This is in reaction to the supporting document presented for 11 Tolmers gardens from the developer

The documents purpose is that the planning presented in 2023 is a milder version of what was rejected in 2022 in the motion to get this approved (considering this was rejected then for the same reasons presented now)

PROPOSED GROUND FLOOR PLAN  
SCALE 1:100

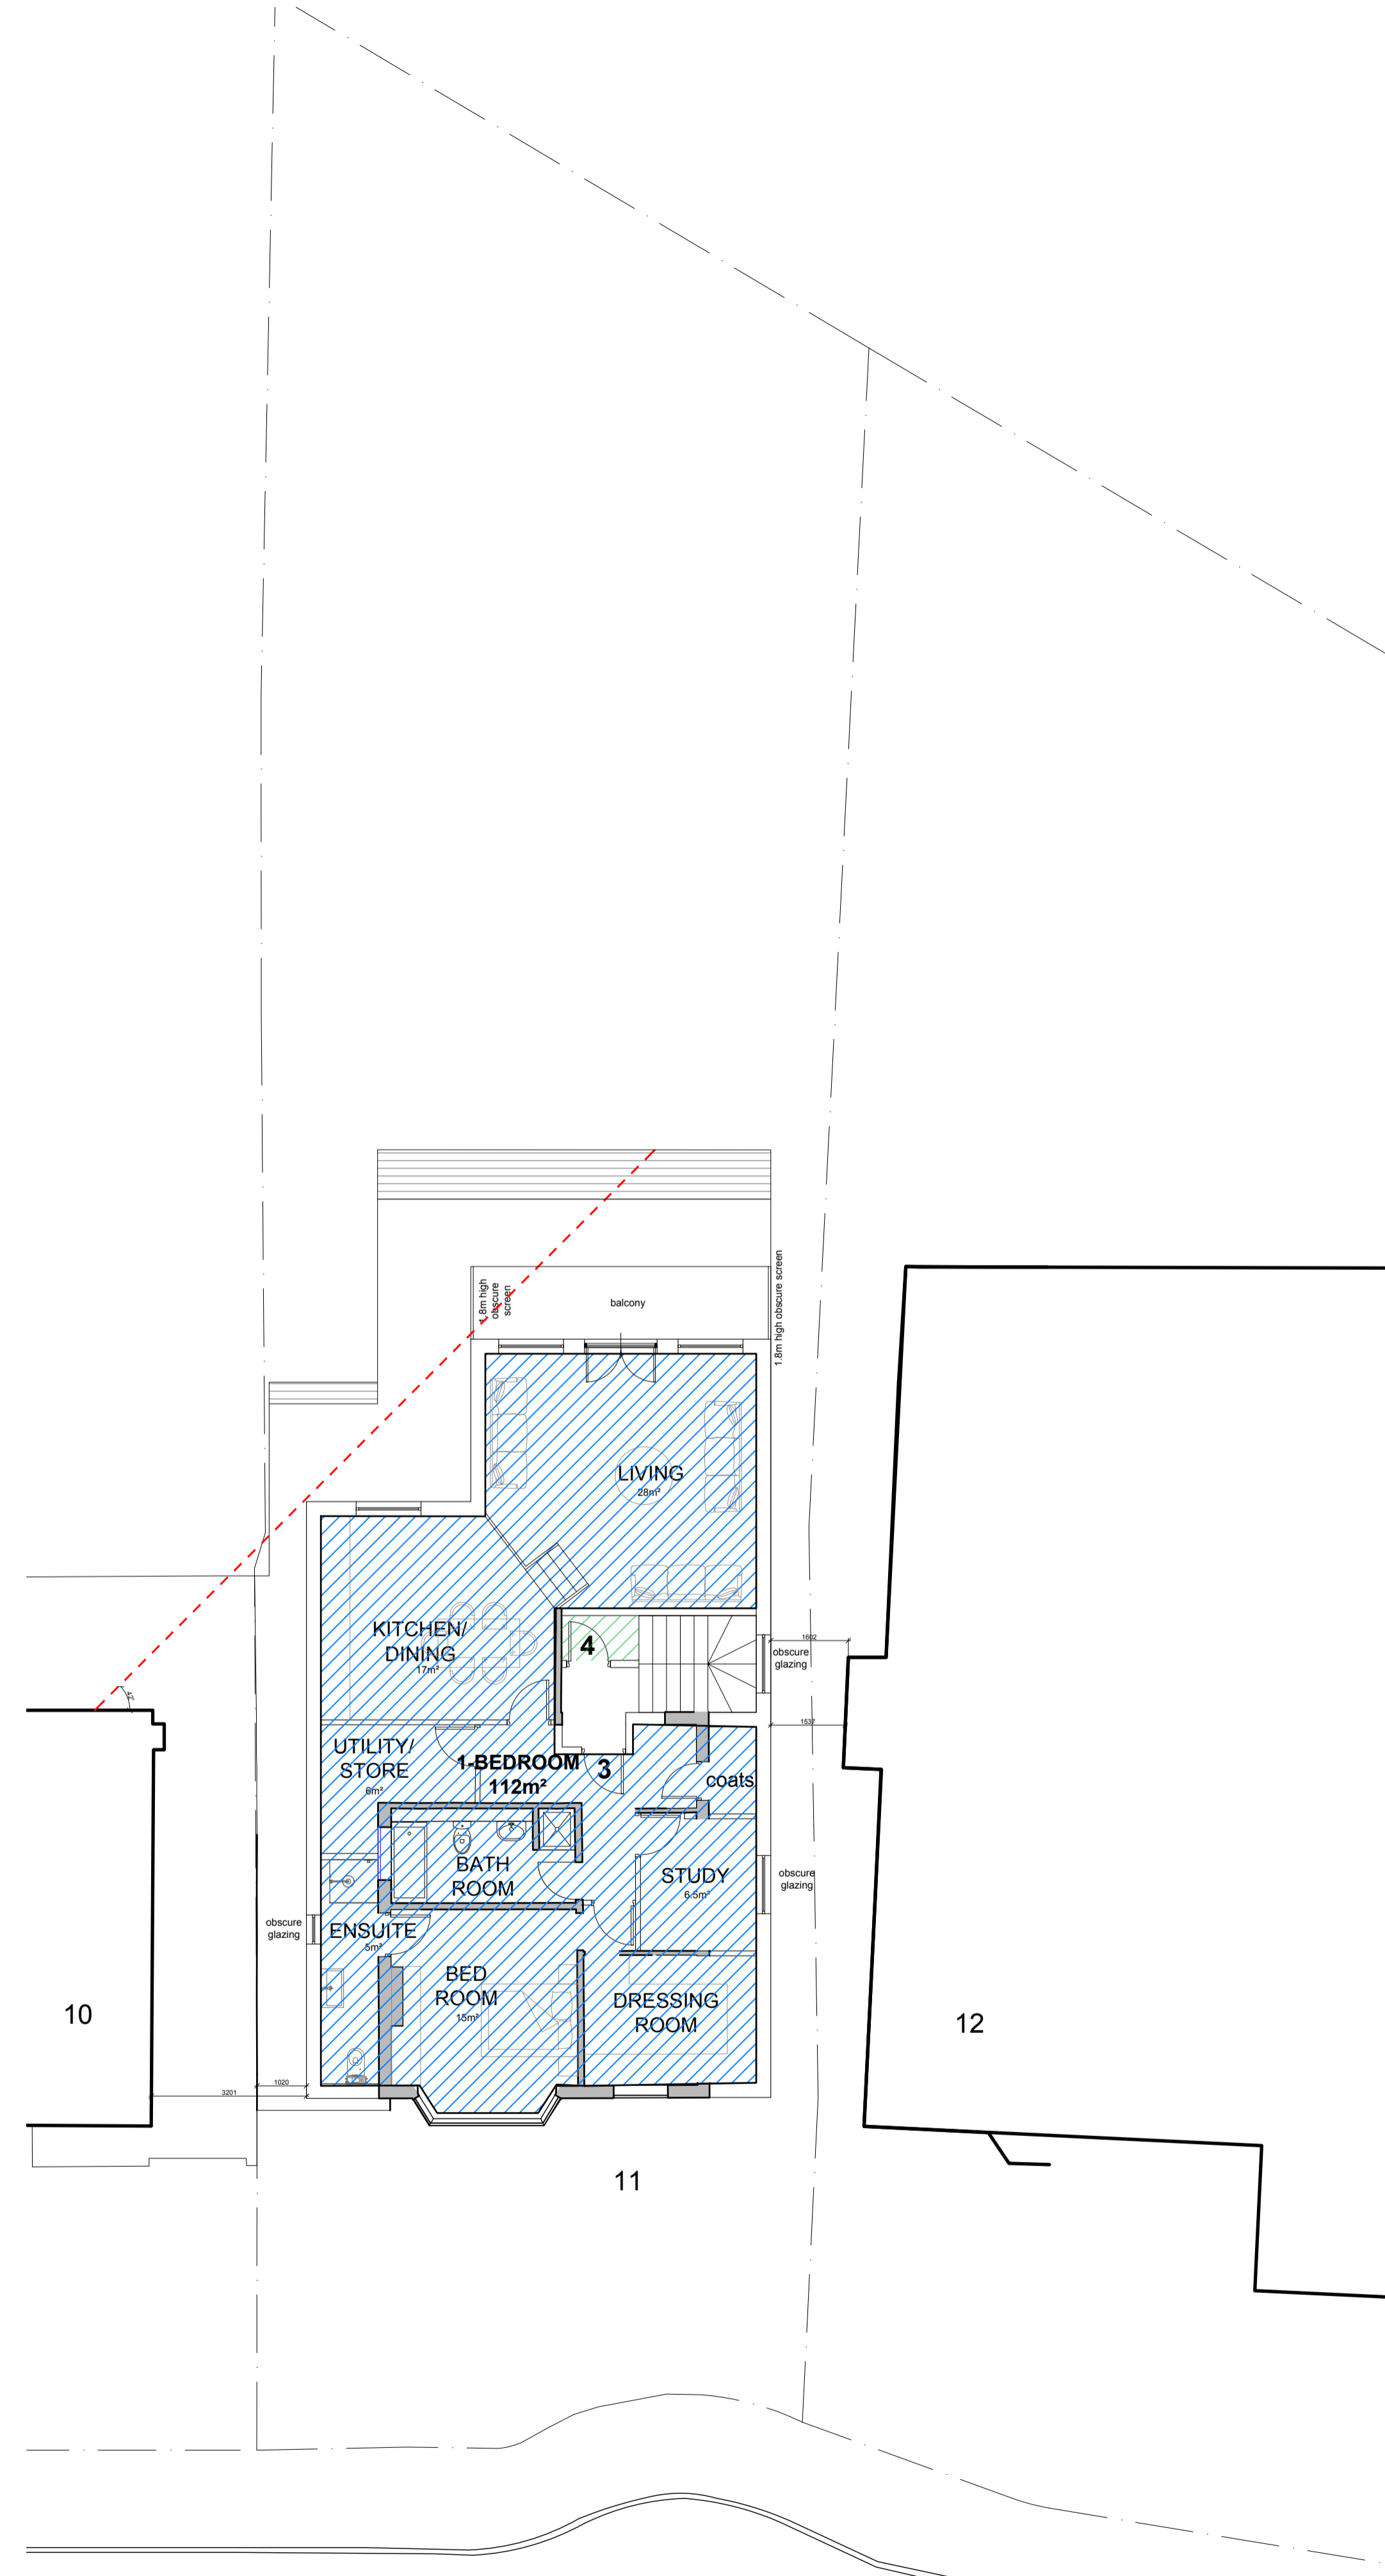
The main comment is that the extension projecting in the garden is actually only 4m now in compared to previous planning in 2022 of 9m

This is actually incorrect on studying this with the planning/scale aprox. and grounds this is actually 6M rather than 4M a reduction of 3M only.

The difference also in the planning application of 2023 compared to 2022 is the widening of No 11 by 2.3M between No 11 & 12 alleyway and the increase in height/alleviation by 1.2M to No 11 building.

The reducing the alleyway in between 11 & 12 is a 60% light reduction by size decrease so to state there is no light reduction is nonsense and again deliberately incorrect

Plan below produced on plan of No 11 site by Developer in RED. The land now capturing/ encompassing the boundaries of the property i bought into at 12 Tolmers Gardens as shown above. Again the communal amenity for 11 & No 12? When? How? who was notified of this? When was the residents of 12 Tolmers Gardens noticed of this take back of boundary land/Garden? NEVER??

To be able to sit and read and have a coffee on the bench in the garden with this smell of large refuse bins/ toxic smells creating pollution and flies especially in the summer heat would be impossible.

Also to use the garden of 12 Tolmers for a cycle storage for No 11 again total abuse. This was always No 12 boundary
